# **SCOPING OPINION:**

## **Proposed Connah's Quay Low Carbon Power Project**

**Case Reference: EN010166**

**20 March 2024**

Environmental Statement Volume III
Figure 1-1: Location of the Proposed Connah's Quay Low Carbon Abated Generating Station

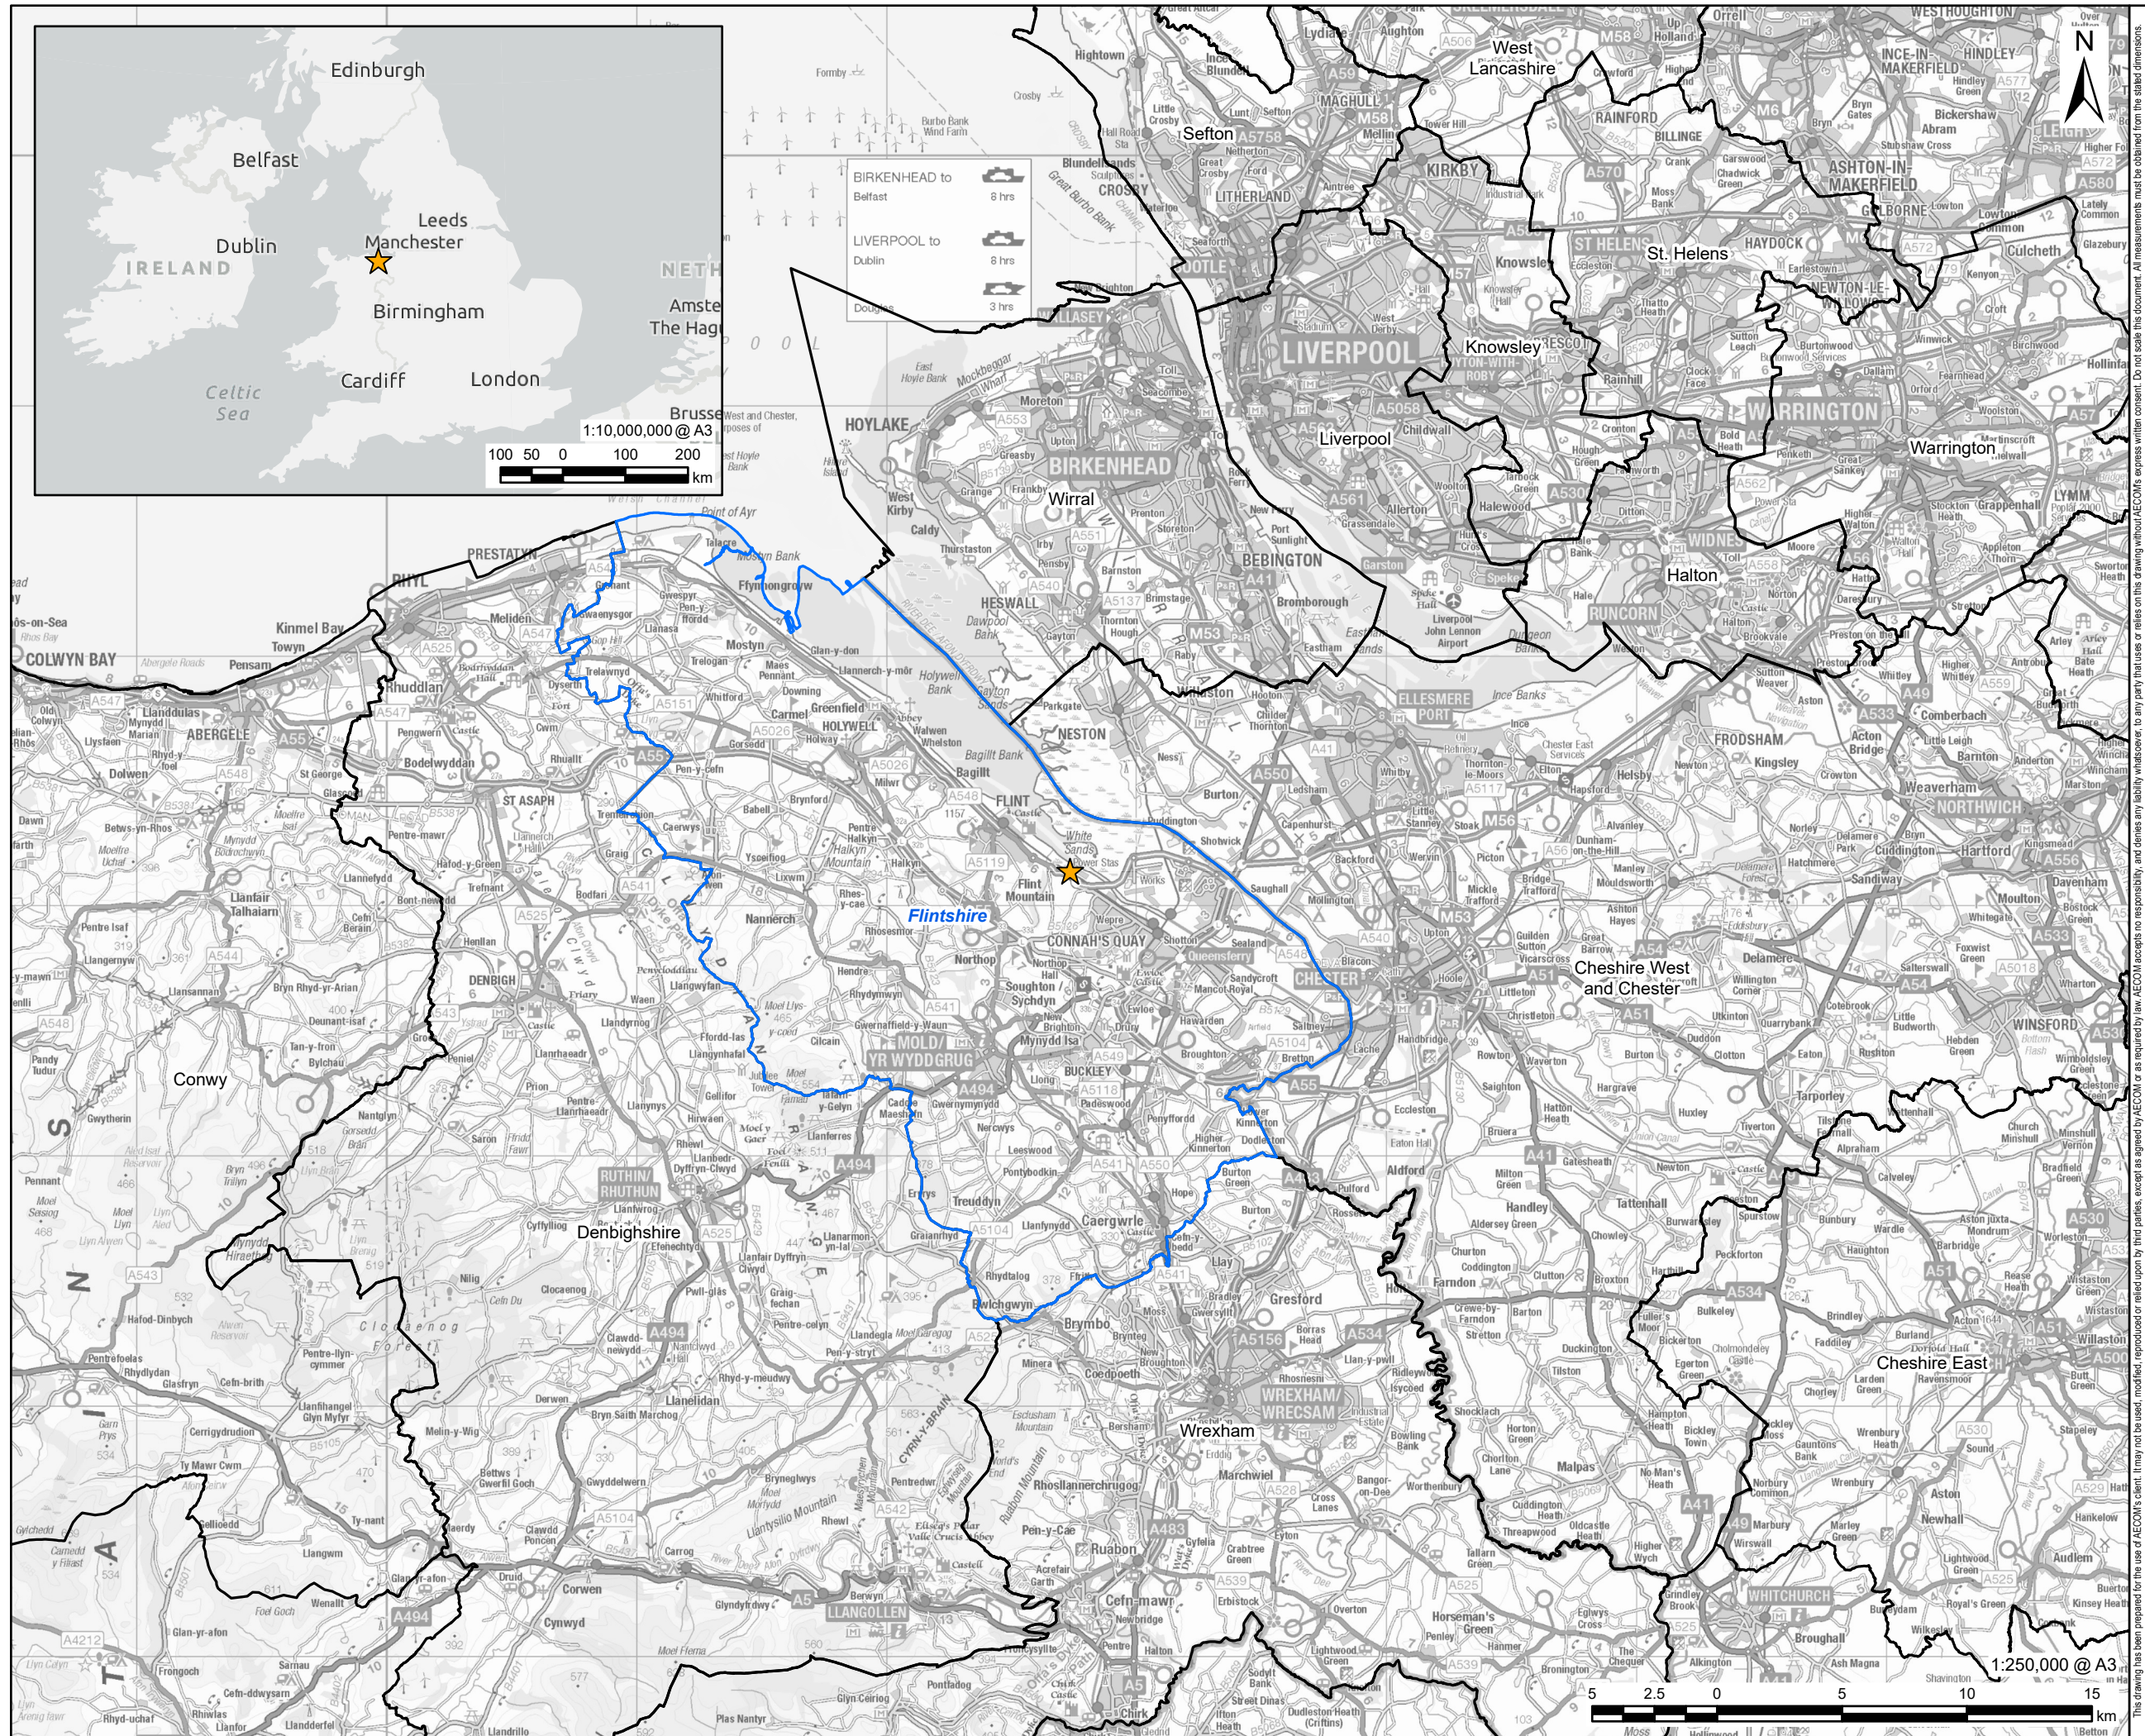
ID	Ref	Description	Inspectorate's comments
2.1.1	Figure 1-2	Thickness of red line boundary	It would assist the reader if a thinner red line boundary could be used to show the exact land required and assessed for the Proposed Development.
